July 27, 2022

Re: SAIA – *Technical Review 1*
PA 22025

SUBJECT: PA22-025 SAIA Marysville
NE corner of State Avenue and 128th Street NE
APN: 30050400300200

1 FENCE DETAIL - VEHICLE GATE
3/8" = 1'-0"

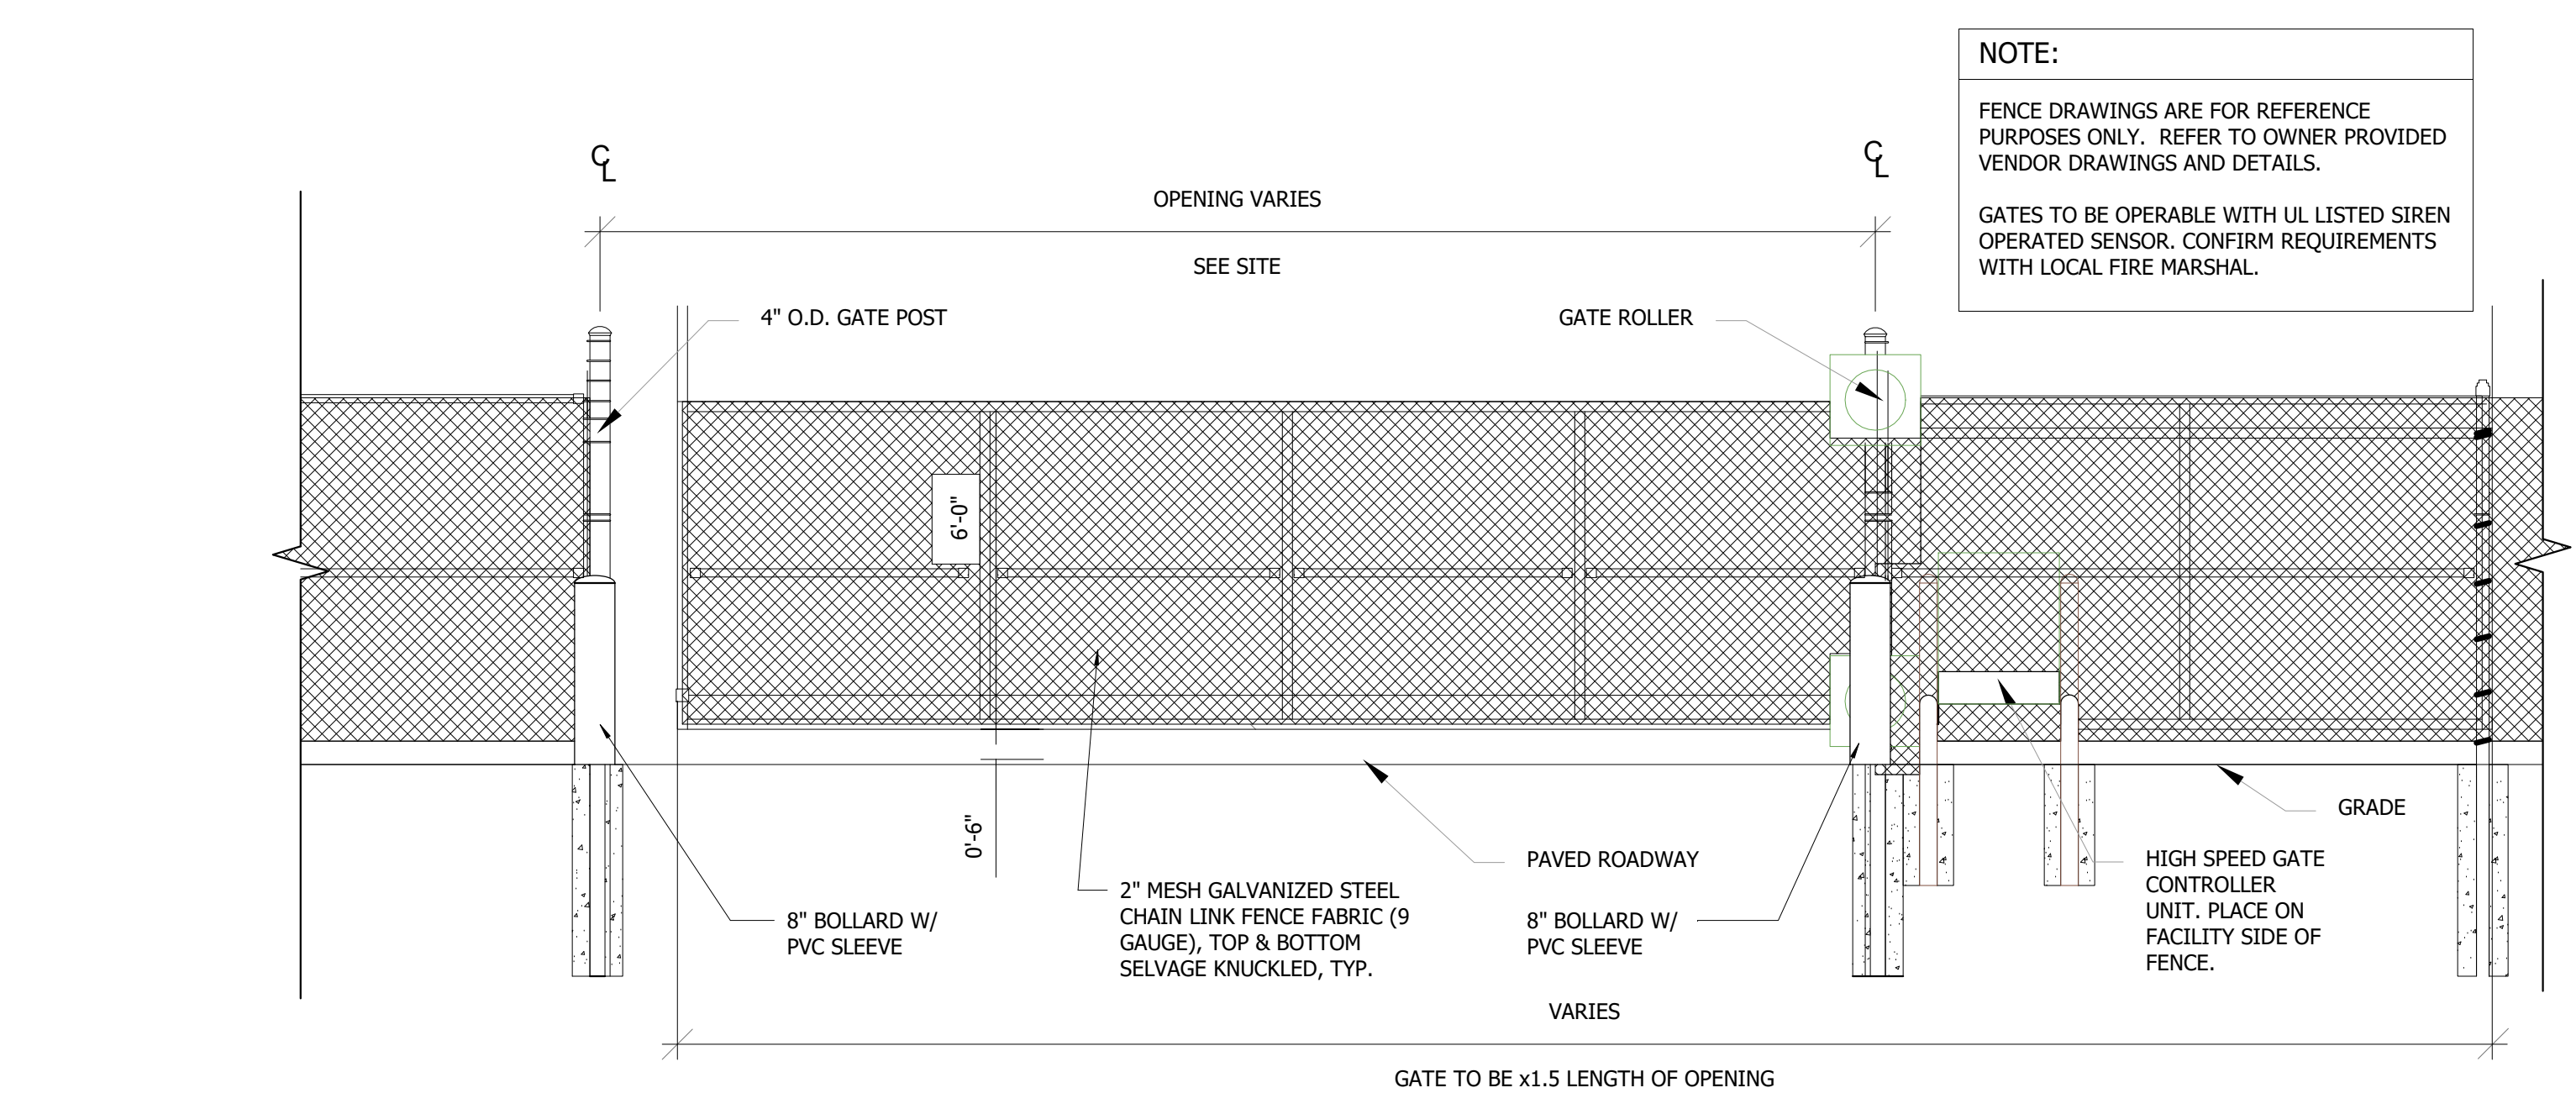
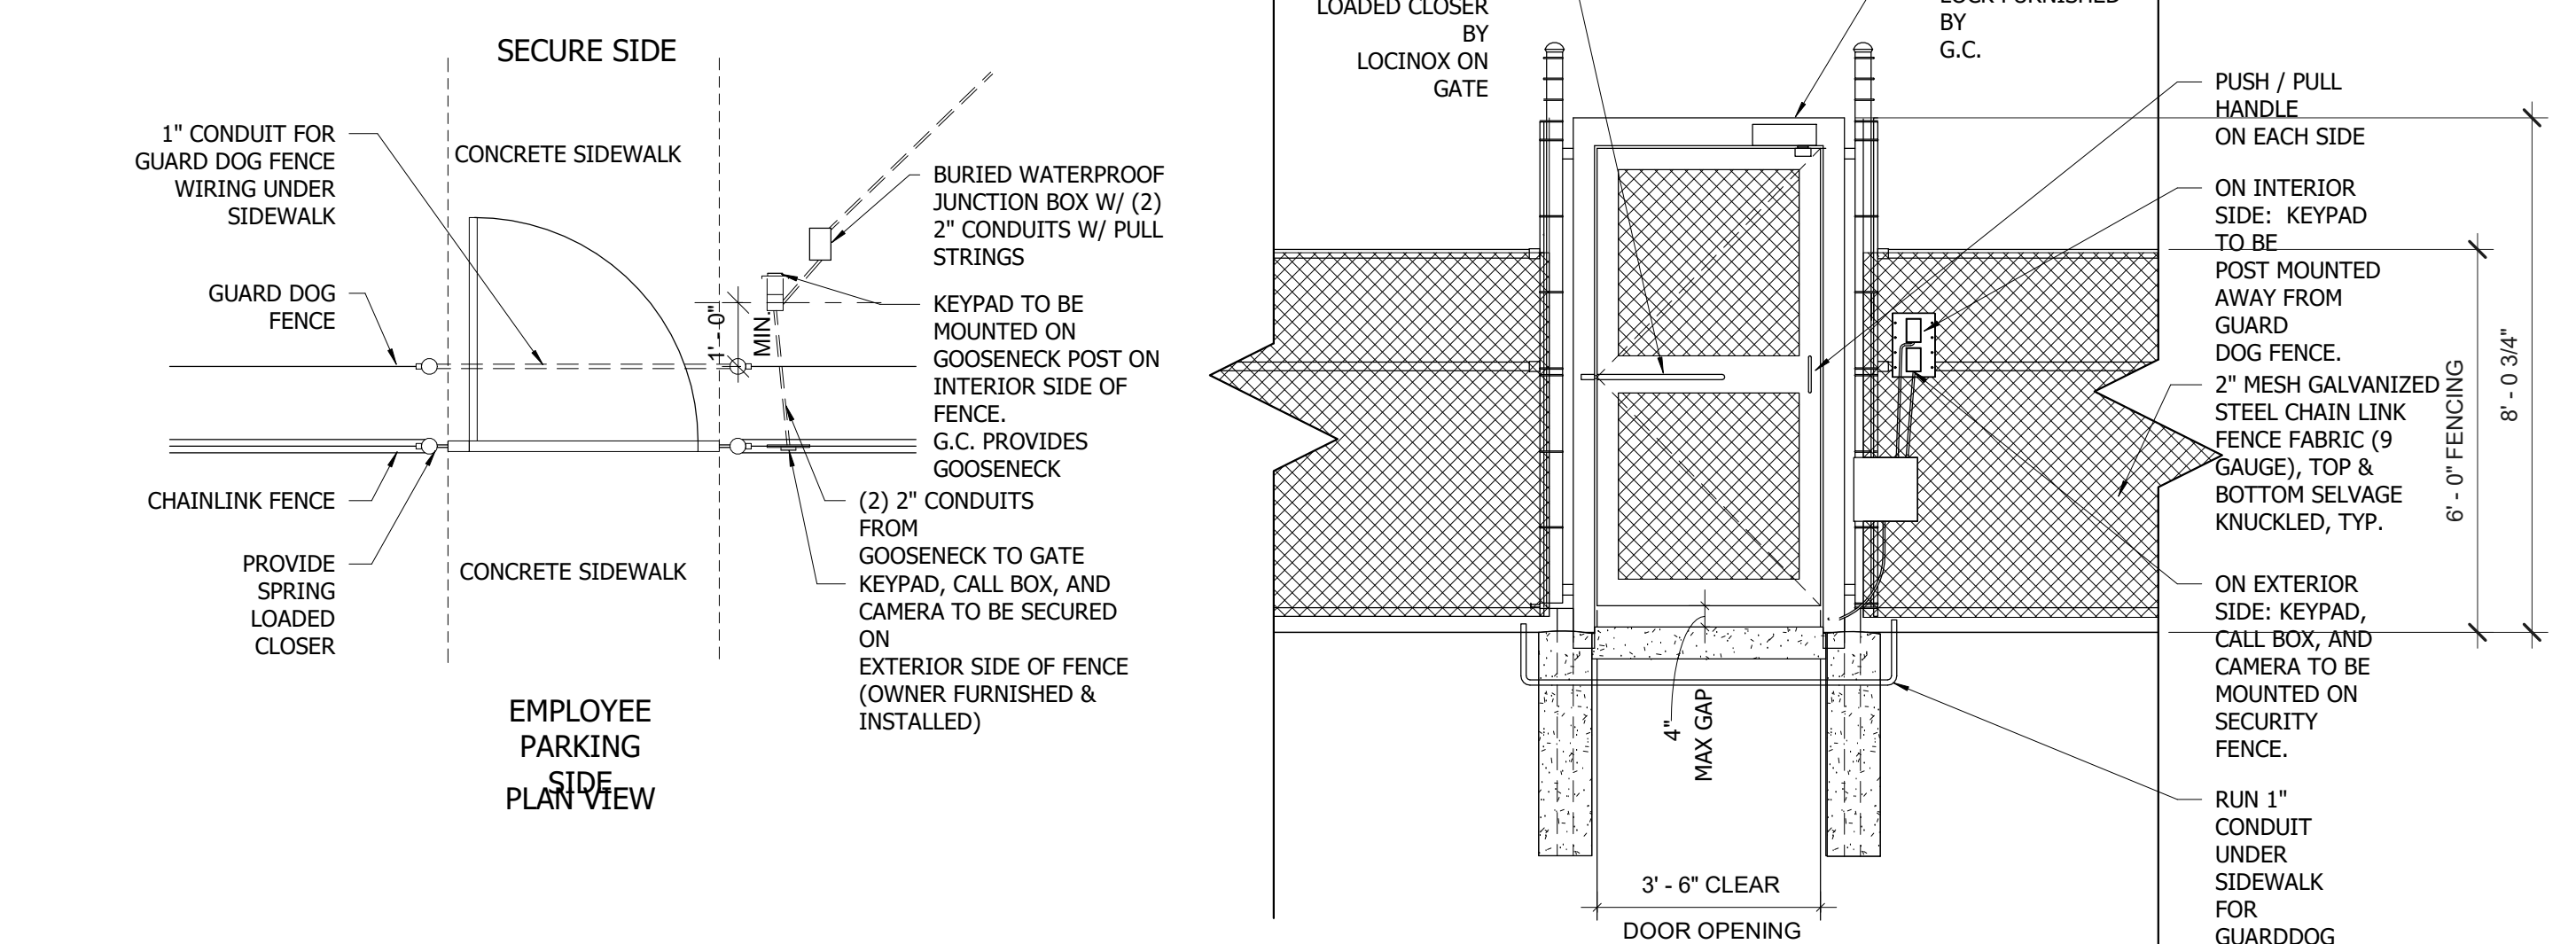
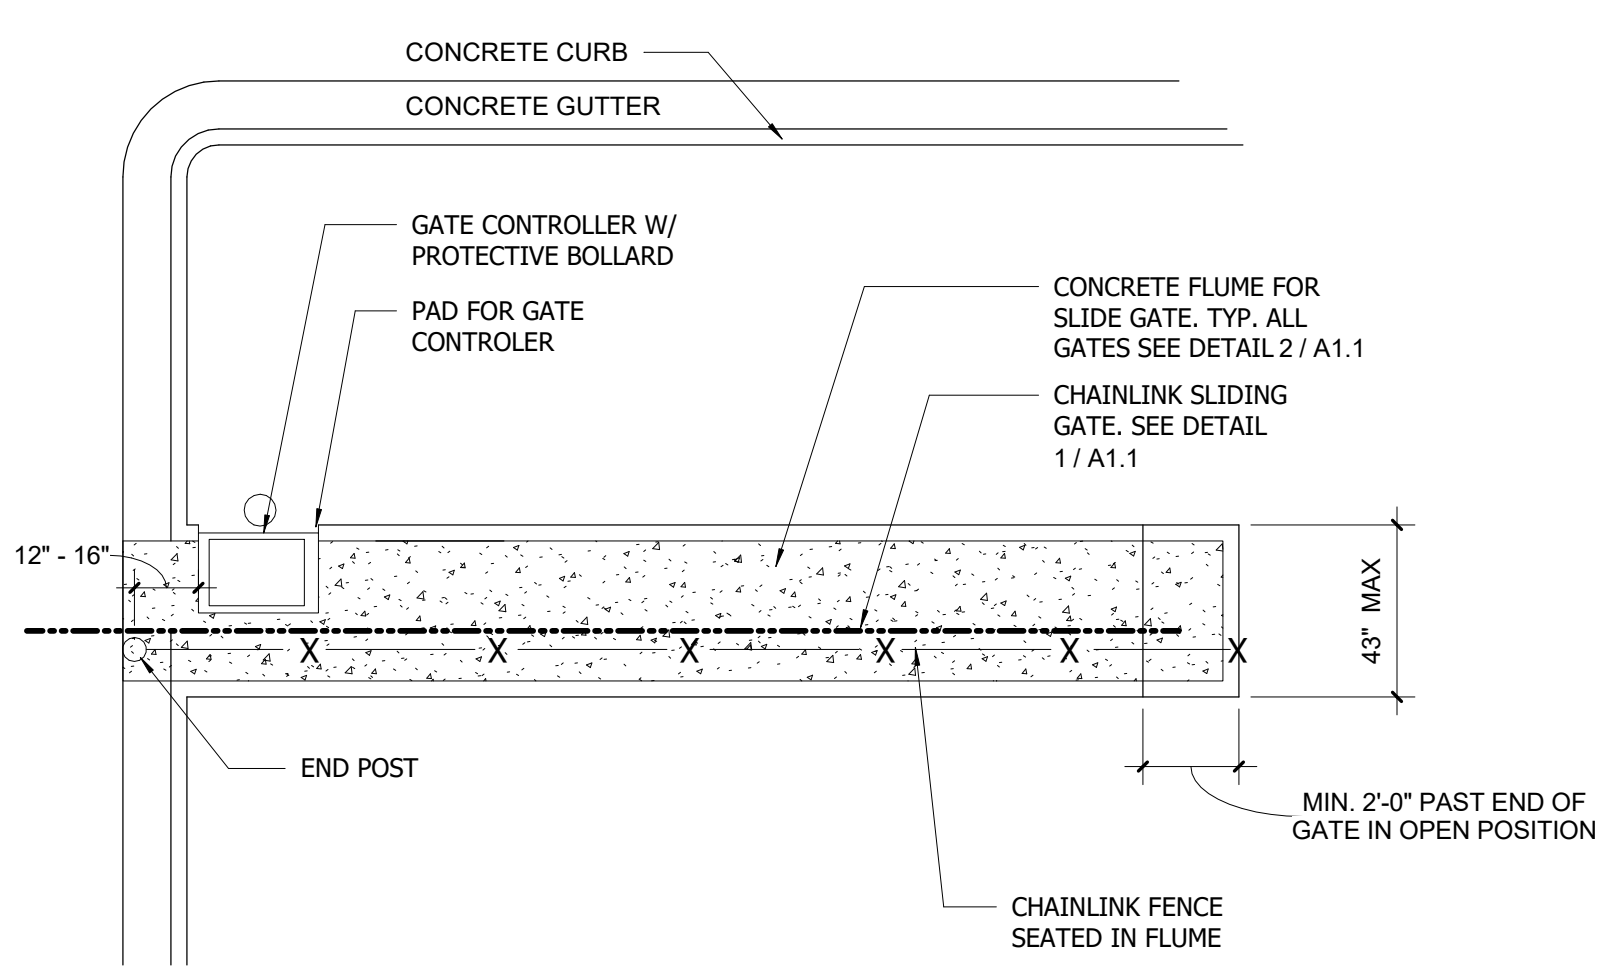
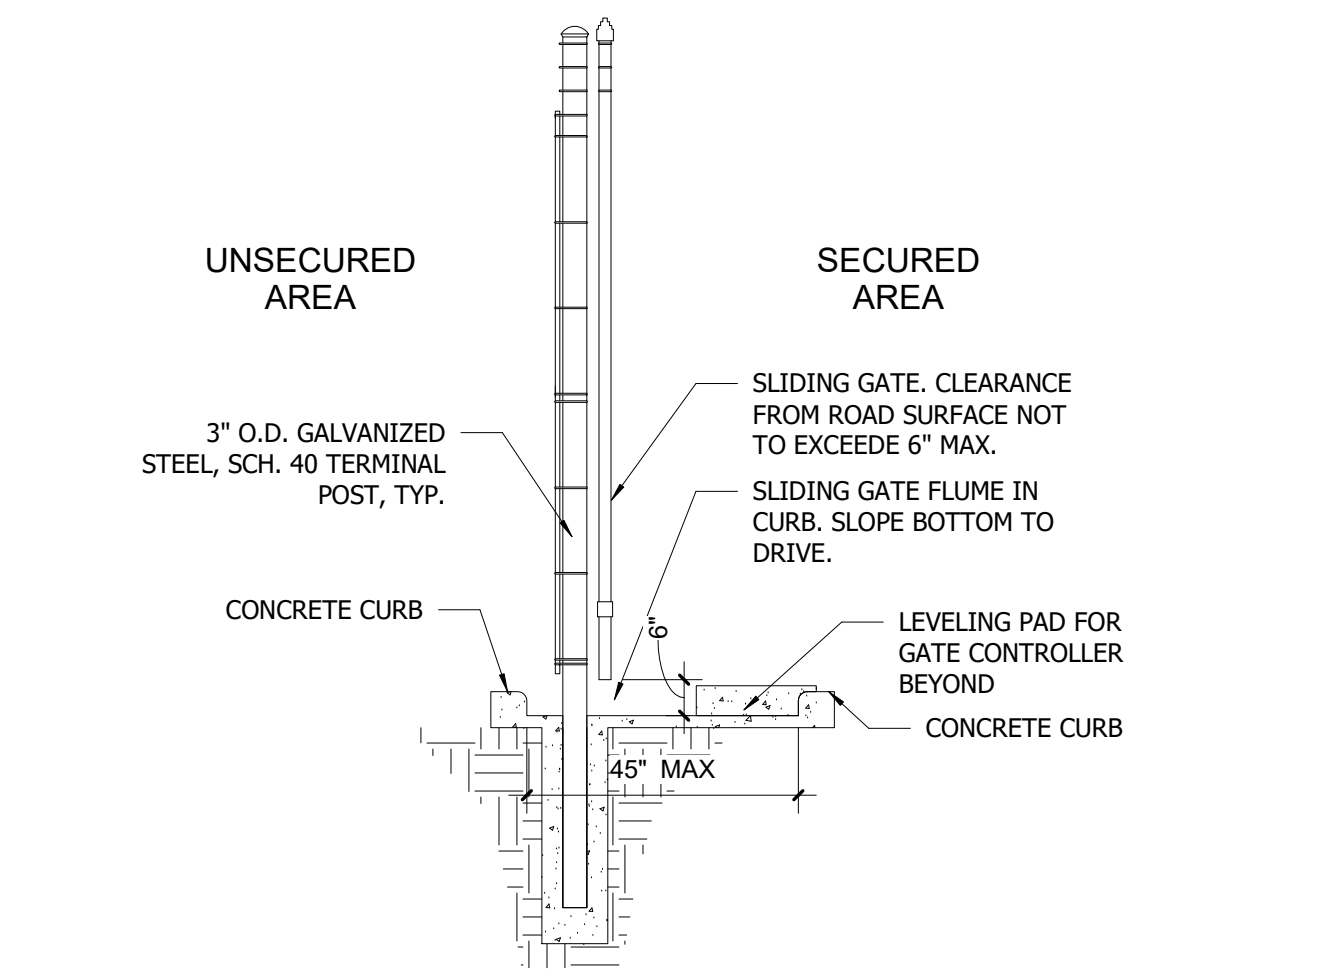
- i. Provide details of the proposed security gates, security fencing, retaining wall fencing and detention bond fencing.
- j. Retaining walls shall be designed in accordance with [MMC 22D.050.030](#) (4). If retaining walls taller than four feet are used, as measured from the average grade, and are visible from the street or adjacent property, they shall be terraced so that no individual segment is taller than four feet; provided, that where adjacent properties are not adversely affected or the retaining wall is minor in nature, the community development director may reduce or waive these standards. Terraced walls shall be separated by a landscaping bed at least two feet in width. Alternative landscaping treatments will be considered, provided they reduce the bulk and scale of the retaining wall and enhance the streetscape or transition between properties.
